**City of Portland, Maine – Building or Use Permit Application** 389 Congress Street, 04101, Tel: (207) 874-8703, FAX: 874-8716

# BUILDING PERMIT REPORT

DATE: 24 NOV. 98 ADDRESS: 261 Danforth ST. CBL 057-B-022  
REASON FOR PERMIT: Replace Fire Escape  
BUILDING OWNER: Brad Morrison  
CONTRACTOR: Rent-A-Husband  
PERMIT APPLICANT: ↑  
USE GROUP R-2 BOCA 1996 CONSTRUCTION TYPE 5B

Stair Sectional

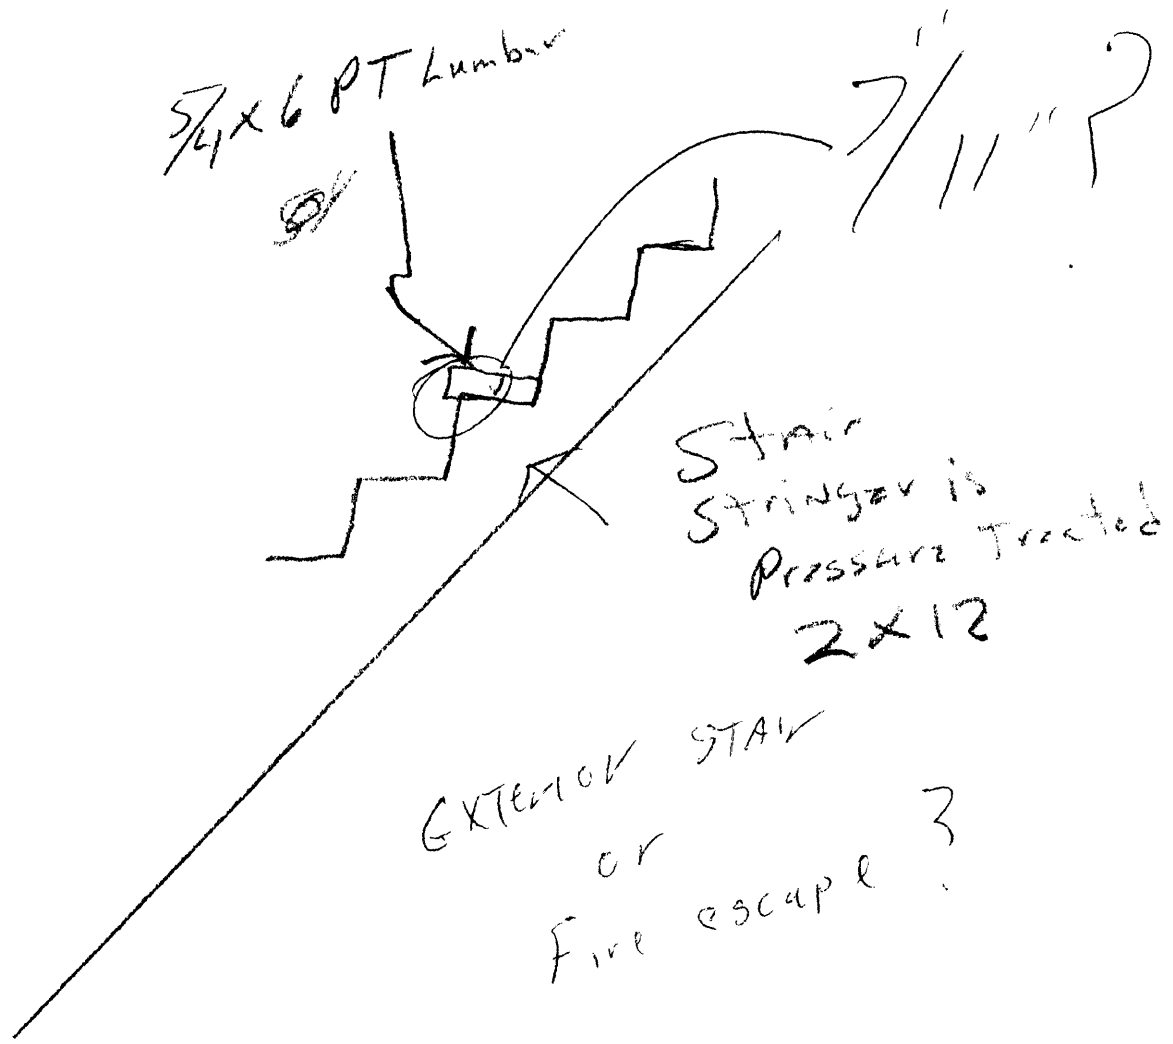
\* 32. IF This is an exterior Stairway IT MUST MEET The requirements of Section 1014.12 of the bldg. code

He will have more installed  
& will lengthen stair-stands,  
stairs

Deck Sections

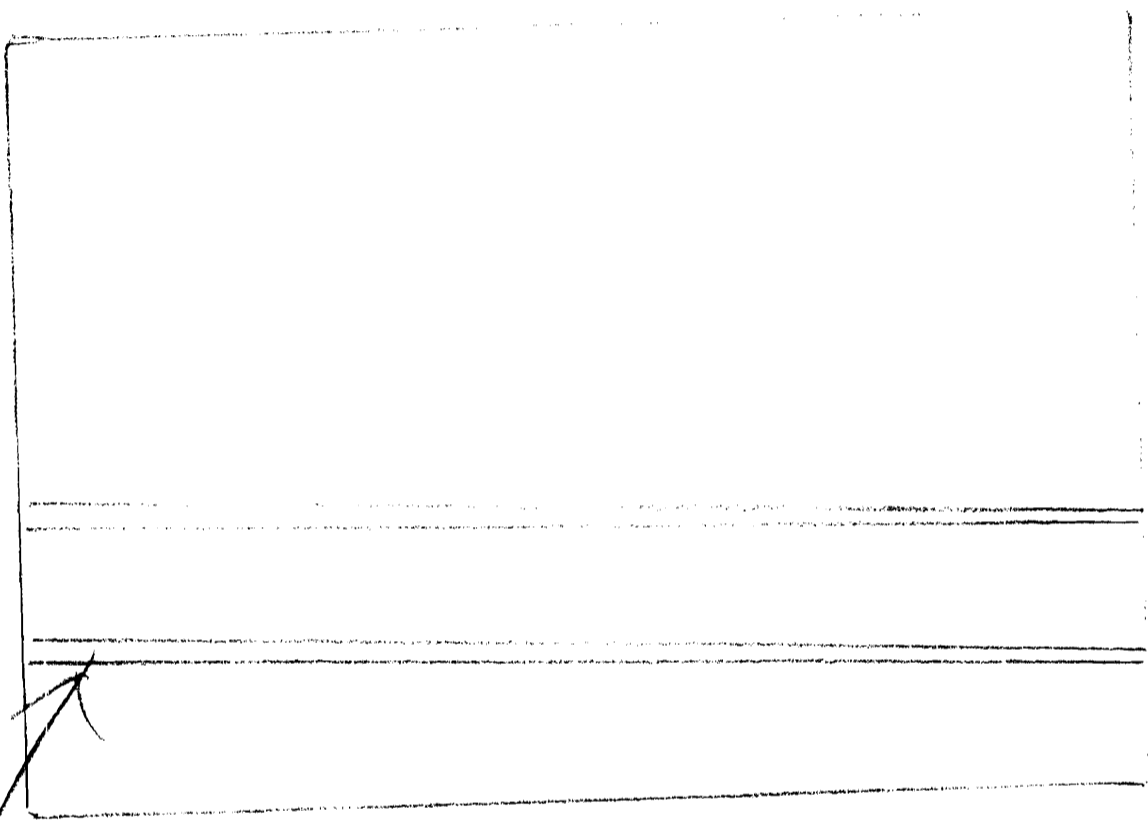
Inadequate guardrail system, need nangers, not properly bolted to sauna tube, not properly bolted to house -

Ballast Sections

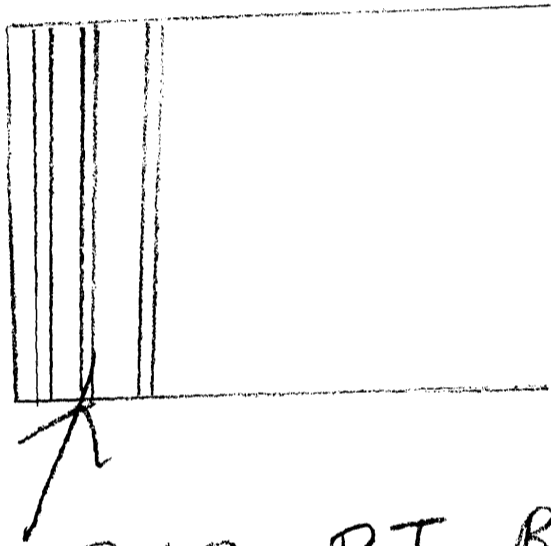
7. Sound transmission control in residential building shall be done in accordance with Chapter 12 section 1214.0 of the city's building code.
8. Guardrails & Handrails: A guardrail system is a system of building components located near the open sides of elevated walking surfaces for the purpose of minimizing the possibility of an accidental fall from the walking surface to the lower level. Minimum height all Use Groups 42" , except Use Group R which is 36". In occupancies in Use Group A, B, H-4, I-1, I-2 M and R and public garages and open parking structures, open guards shall have balusters or be of solid material such that a sphere with a diameter of 4" cannot pass through any opening. Guards shall not have an ornamental pattern that would provide a ladder effect. (Handrails shall be a minimum of 34" but not more than 38". Use Group R-3 shall not be less than 30", but not more than 38".) Handrail grip size shall have a circular cross section with an outside diameter of at least 1 1/4" and not greater than 2". (Sections 1021 & 1022.0) - Handrails shall be on both sides of stairway. (Section 1014.7)
